PACIFIC HIGHWAY AND WILSON STREET, CHATSWOOD | DESIGN INTEGRITY PANEL REPORT

This letter has been prepared on behalf of the Design Integrity Panel (**DIP**), in relation to the Design Integrity Process for the State Significant Development Application at 849, 853, and 859 Pacific Highway and 2 and 8 Wilson Street, Chatswood.

Table 1 – Design Integrity Panel Comments

ELEVATION 2 (East and North, not to scale) - 849 - 859 Pacific Highway, and 2 and 8 Wilson Street, Chatswood

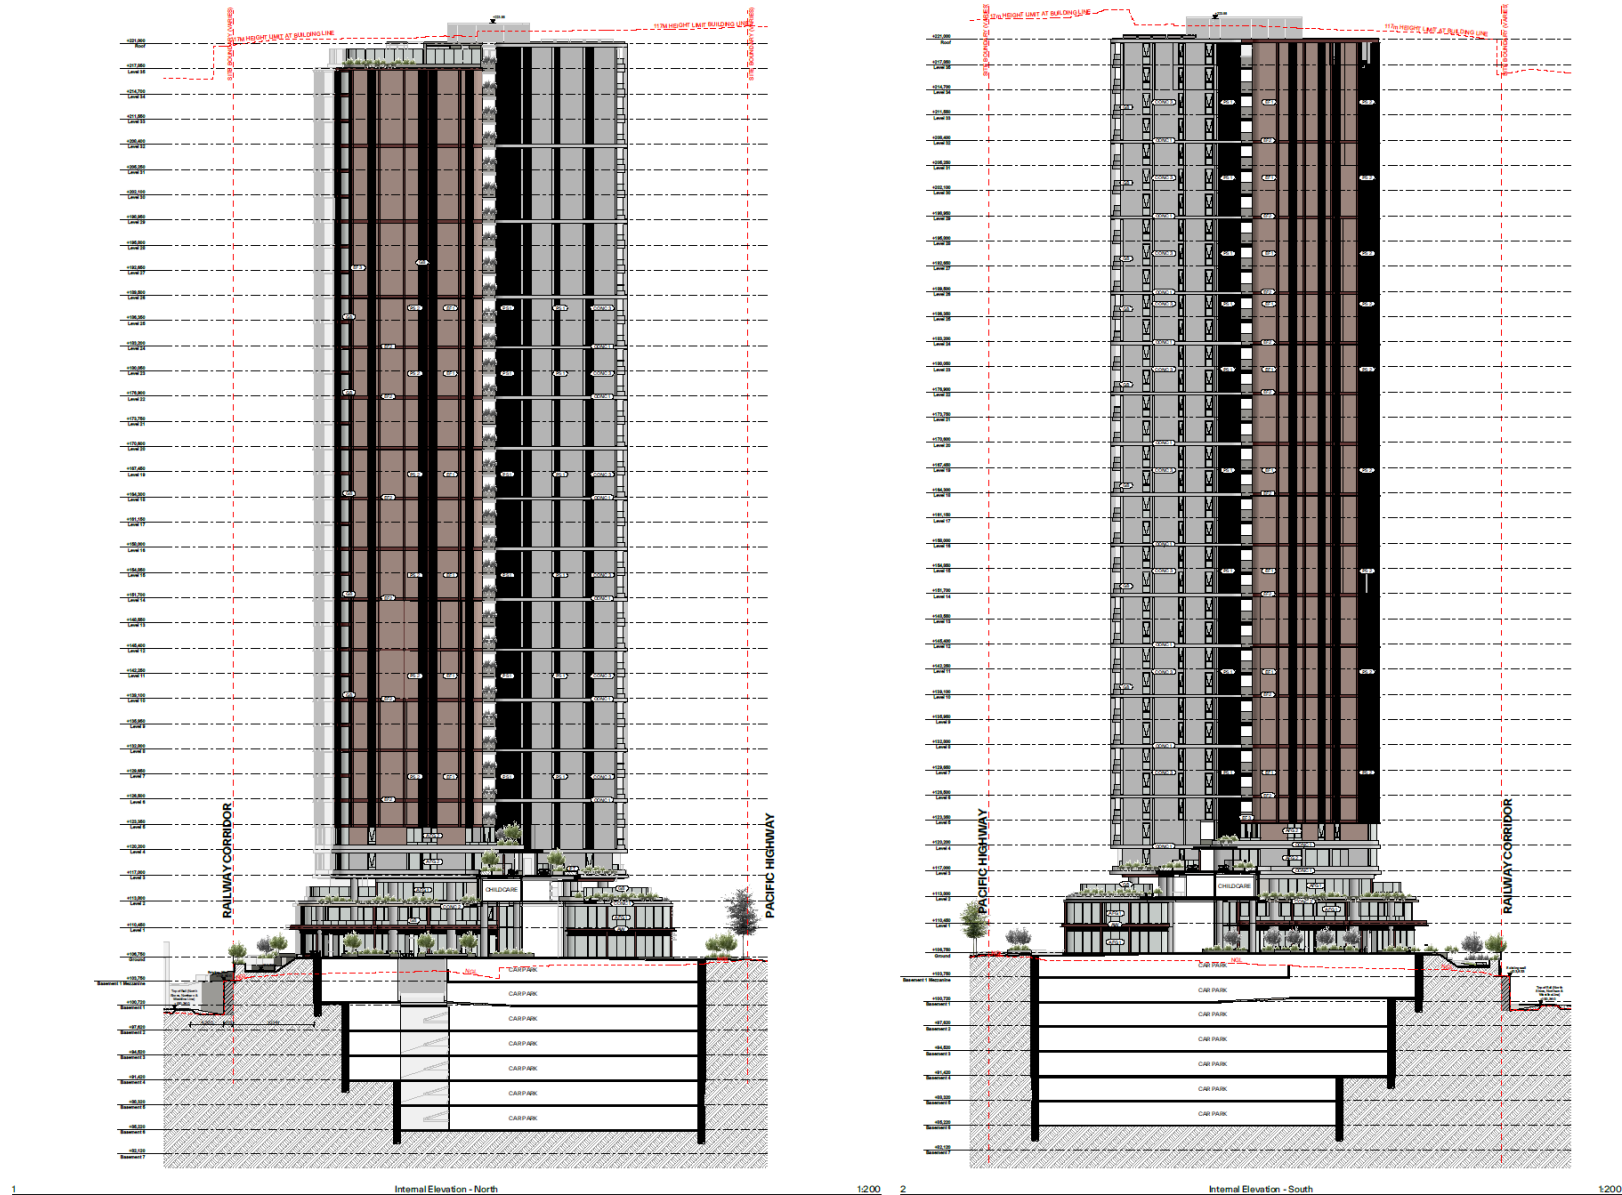
- Detailed descriptions and drawings that explain and illustrate:
 - How thermal comfort is maintained to the eastern and north-eastern apartments with the introduction of full height glazing and glazed louvres to comply with anti-throw requirements.

- How the visual impact of clutter/personal belongings within these enclosed balconies will be mitigated through solid spandrel elements or similar. This is particularly relevant for lower levels including the affordable housing dwellings when viewed from the public domain, rail corridor and surrounding urban context.

- How the quality and character of the eastern and north-eastern facades compliments the well-considered balance of solid and glazed elements evident in the western and southern facades.

The solid balustrade upturn is proposed to be retained for the first six storeys of the residential component (up to Level 9), including the eastern and northern balconies. This measure not only ensures privacy and manages visual impact but also preserves the solid-to-glazed ratio established throughout the rest of the façade, maintaining the design's consistency and architectural integrity.

Figure 12 Wind Mitigation Treatments – Open Corridors

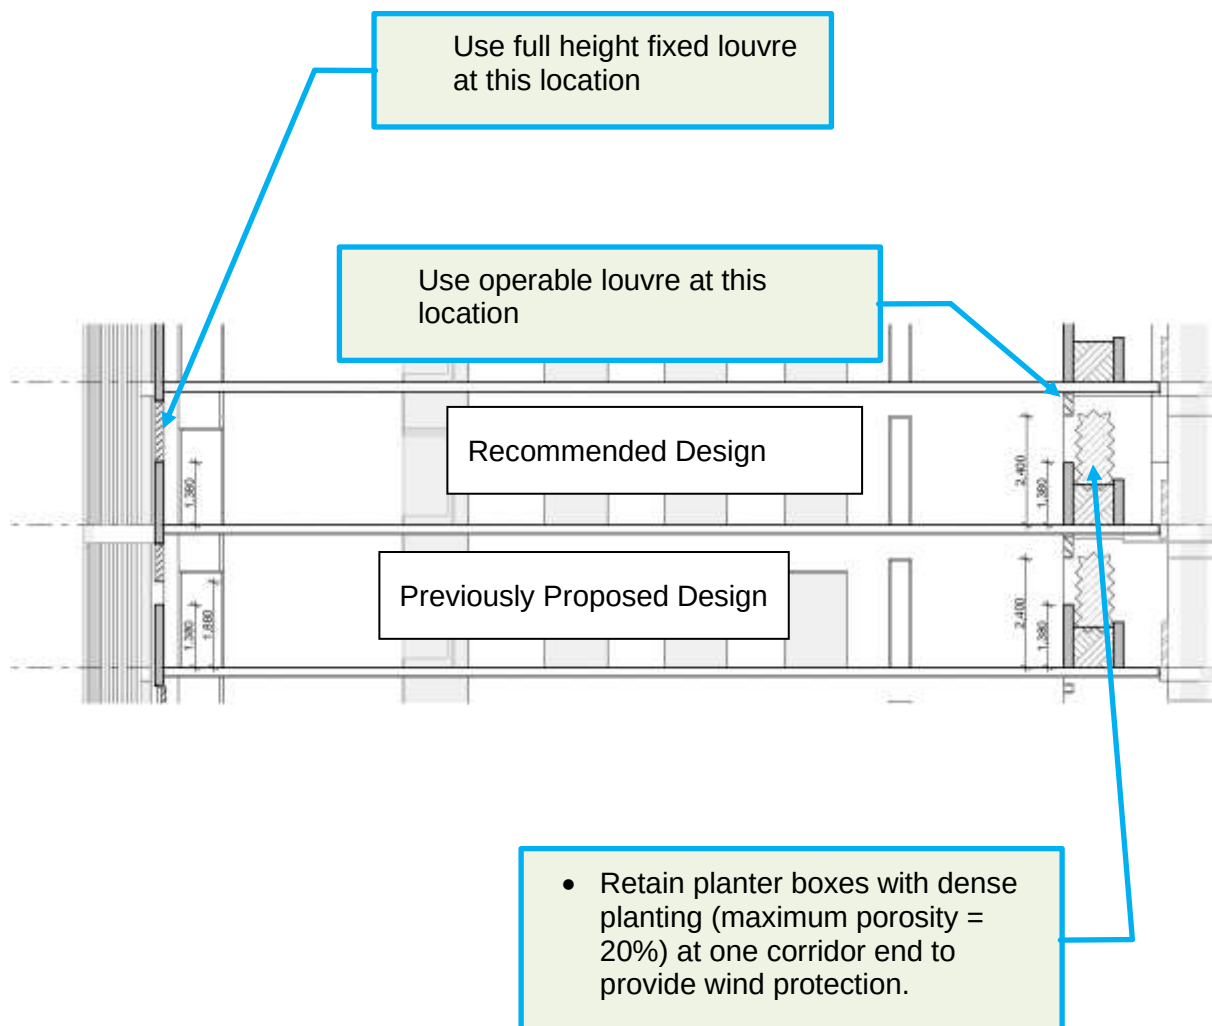
<p>Lift Lobbies to Towers (Levels 3 - 35)</p>	<ul style="list-style-type: none"> ▪ The Panel remains concerned about the amenity of open tower lift lobbies in windy conditions and questions their inclusion in residential buildings of this height and scale. ▪ Prior to submission, obtain detailed technical advice from a wind consultant to test and evaluate the suitability of the current proposal. Integrate any measures identified by the consultant to support increased amenity in adverse conditions

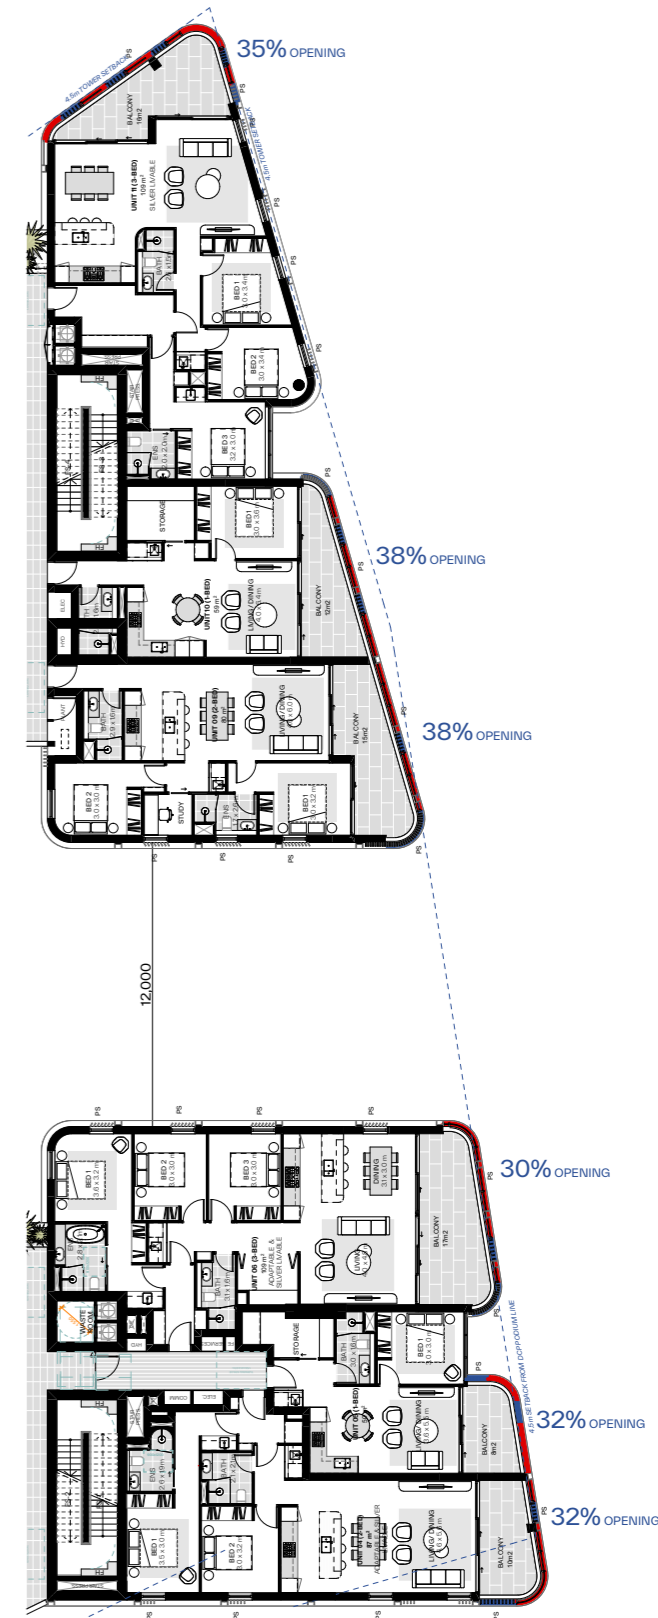
Matter	Panel Comment
<p>Solid Balustrade Upturn to Residential Balconies up to Level 9</p>	<p>The Panel supports the strategy presented in the supplementary rendered views for solid balustrade upturns for all open and semi-enclosed balconies (to comply with anti-throw requirements) up to level 9 but is concerned these are not adequately illustrated and described on the coloured building elevations. The Panel understands the solid components will be located behind the line of glazing. To clearly illustrate the proposed solution, the solid upturns should be represented with a dotted line and notes for submission and assessment.</p>
<p>Thermal Comfort of Apartments to the Eastern Facade</p>	<p>The Panel has reviewed the supporting letter from GreenPerch (1/11/24) outlining the testing and performance of the east-facing apartments including the semi-enclosed balconies. The design team is encouraged to consider the integration of a number of GreenPerch’s recommendations prior to submission including passive shading elements, glazing and frame specification, and ceiling fans to units and balconies, to establish comfortable levels of amenity for all dwellings.</p>
